Our Ref: GM/2014/37

Re: Extension and alterations to 11 Priory Road, Arundel.
Your ref: AB/163/14/HH

Following the recent approval of the above application I enclose our application for non-material amendments, along with three copies of our drawings 2014/37/02 revision A and 2014/37/03 revision A and the application fee of £28.00.

PROJECT			
Proposed extension and alterations to 11 Priory Road, Arundel			
SUBJECT			
Proposed Plans and Elevations			
SCALE 1:100	DATE	DRAWING No 2014 / 37 / 02	Rev A
DRAWN	CHECKED

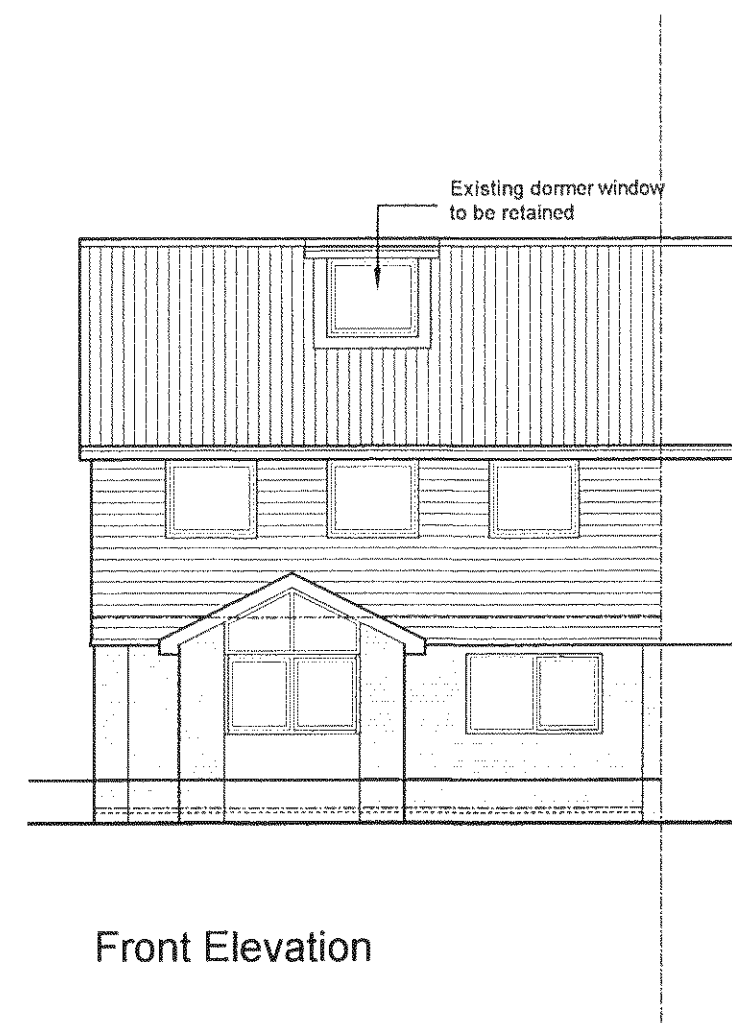
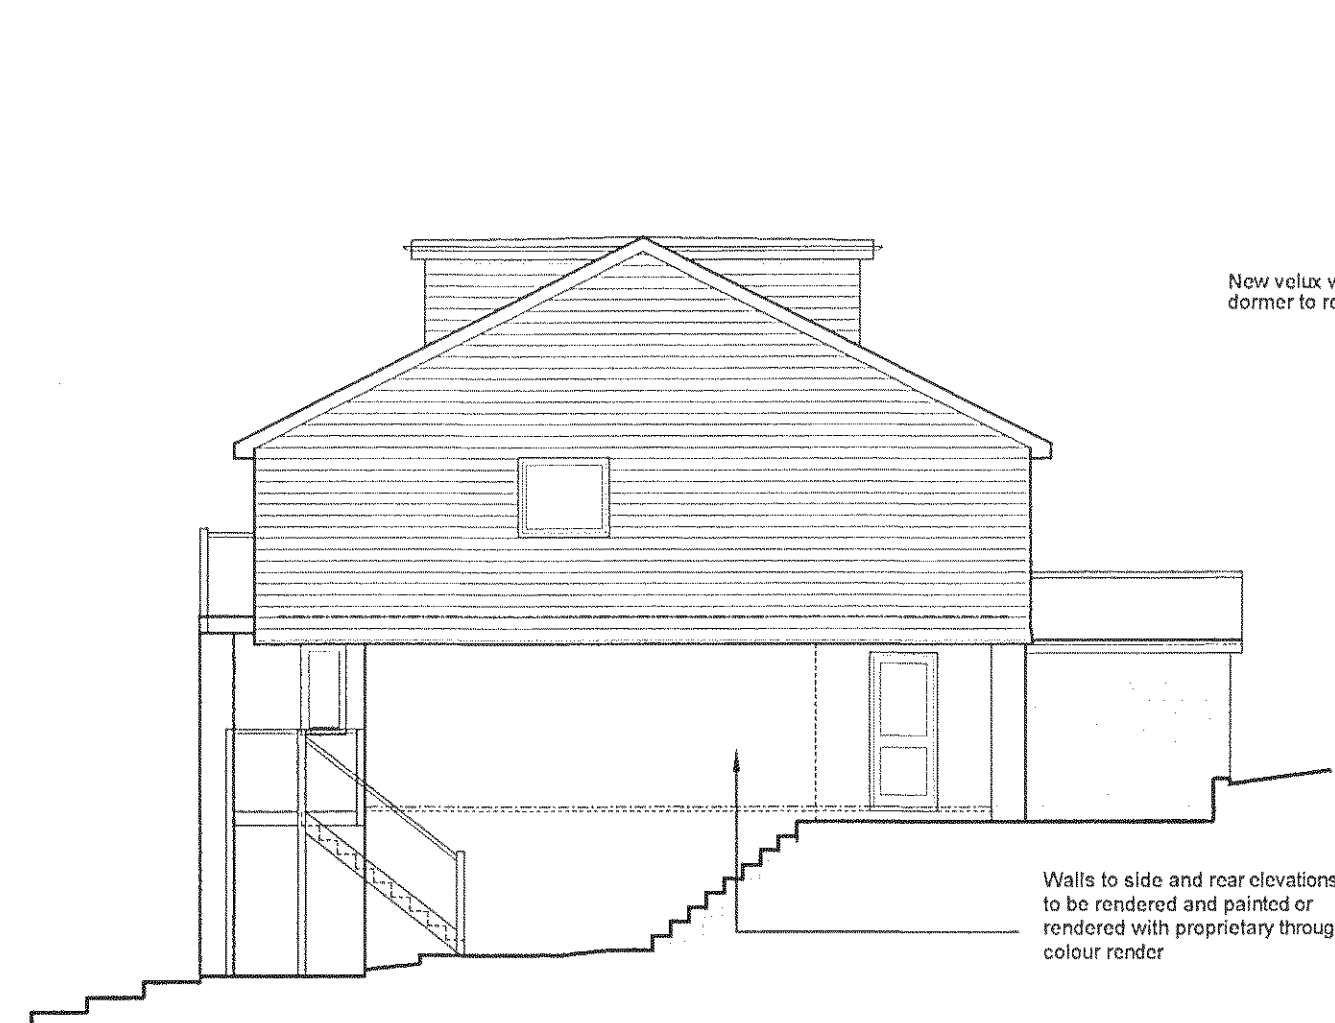
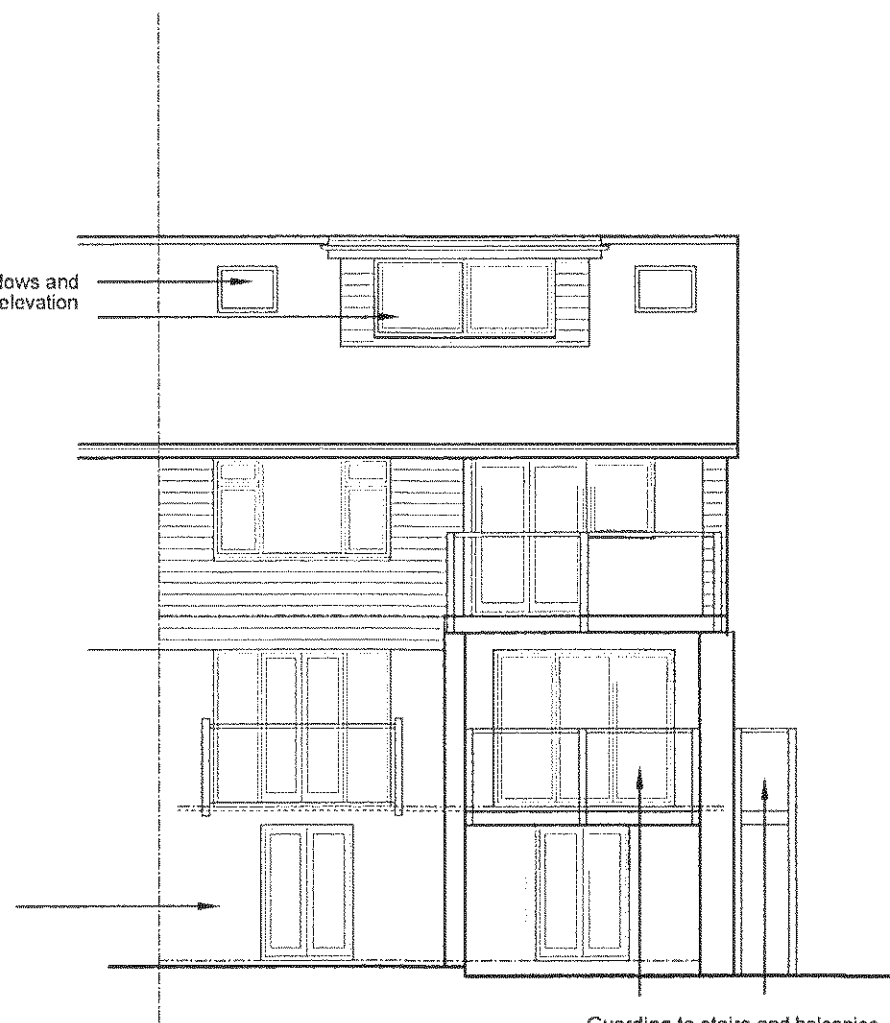
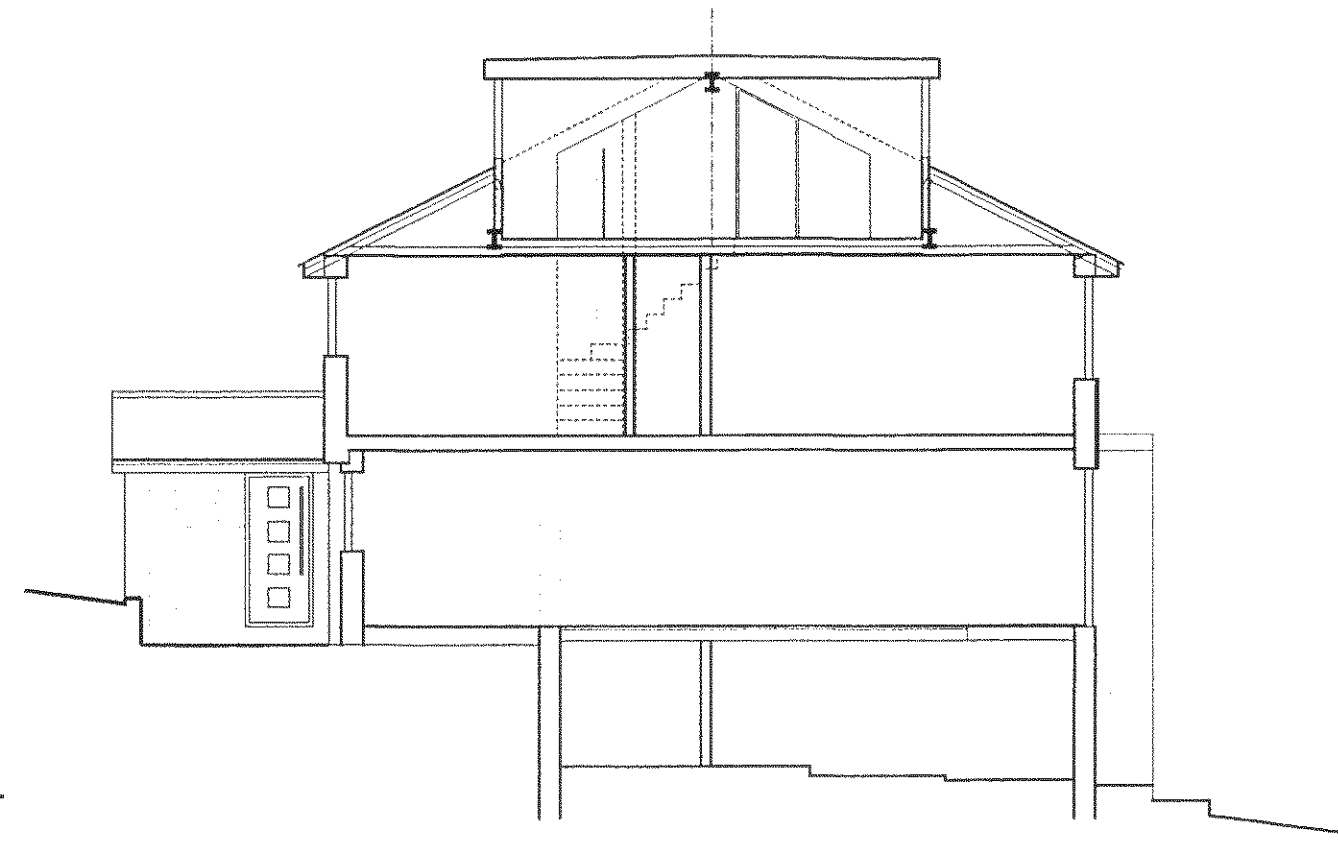
- Extending the proposed porch 1m further forward.
- Increasing the width of the rear dormer by 500mm.
- Adding an additional Velux roof window to the rear elevation
